Arun District Council
Arun Civic Centre
Maltravers Road
Littlehampton
West Sussex BN17 5LF
Planning & Building Control General Enquiries
Tel: (01903) 737756 Fax: (01903) 730442
Dx: 57406 Littlehampton
Minicom: 01903 732765
e-mail: planning@arun.gov.uk
website: www.arun.gov.uk/planning

Application No: FG/2/21/HH
Site Address: 3 Sea Drive Ferring BN12 5HD
Description of works: Erection of a detached garage.

Thank you for your internet representation made on 31st January 2021 which has been recorded as an objection with the comments as follows:

SITE PLAN 1:500 @ A4

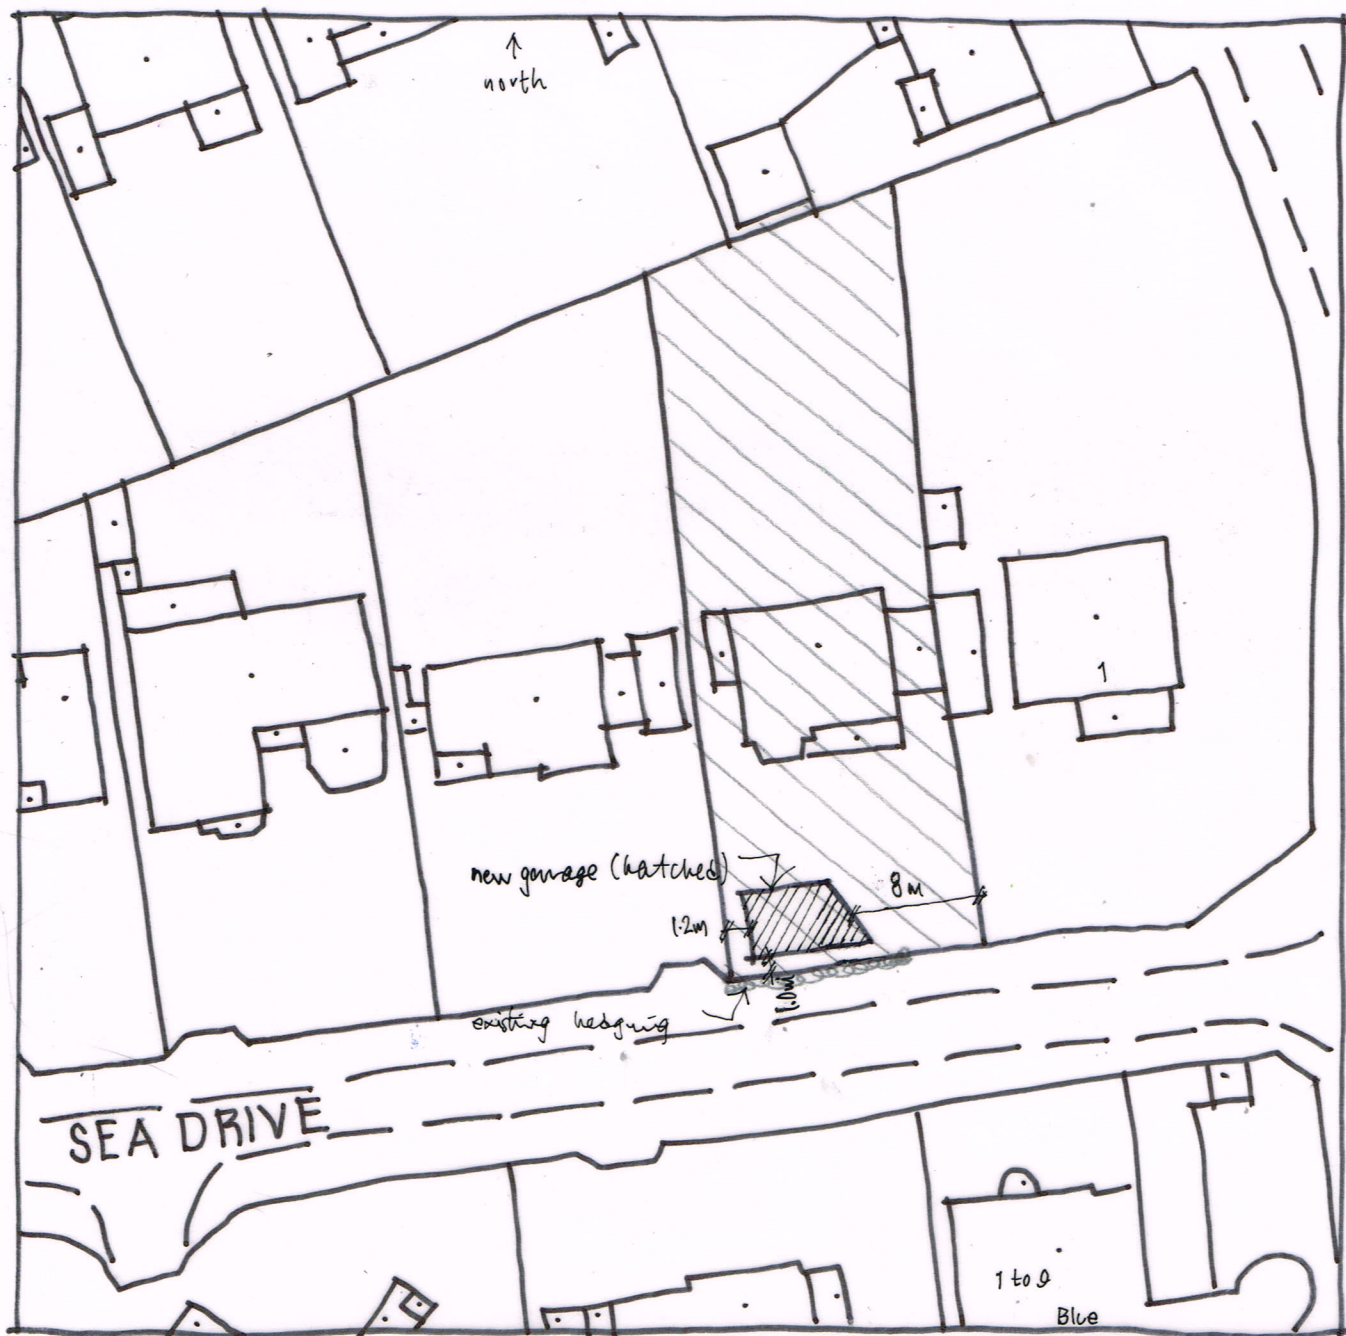
- Building line - the proposed development is well ahead of the building line. This is also in breach of the covenant applied to the properties in Sea Drive.

- If permitted, this would set a precedent to develop buildings to the front, further changing the open aspect and character of the area.
- The property is already highly extended, with 2 storeys up to the boundary on both sides, large front end rear extensions, and outbuildings to the rear, including a cattery. These are not as shown on the 1:500 @ A4 site plan provided with the planning application, giving a false impression.

SECTION 1:50

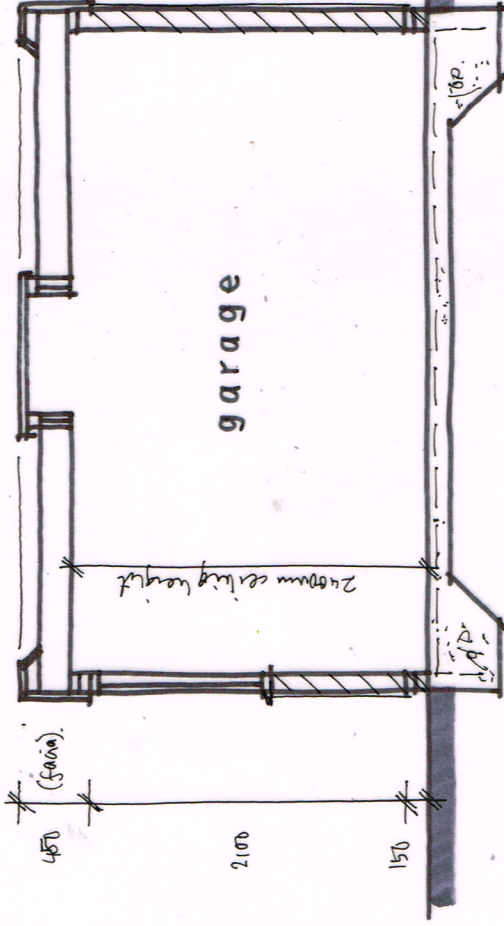
- Why 2 roof lights? These will give light pollution. And why have doors on 3 sides? What will it be used for?
- No dimensions are given, so cannot establish exact size.

- Why the odd-shaped roof with covered open area?
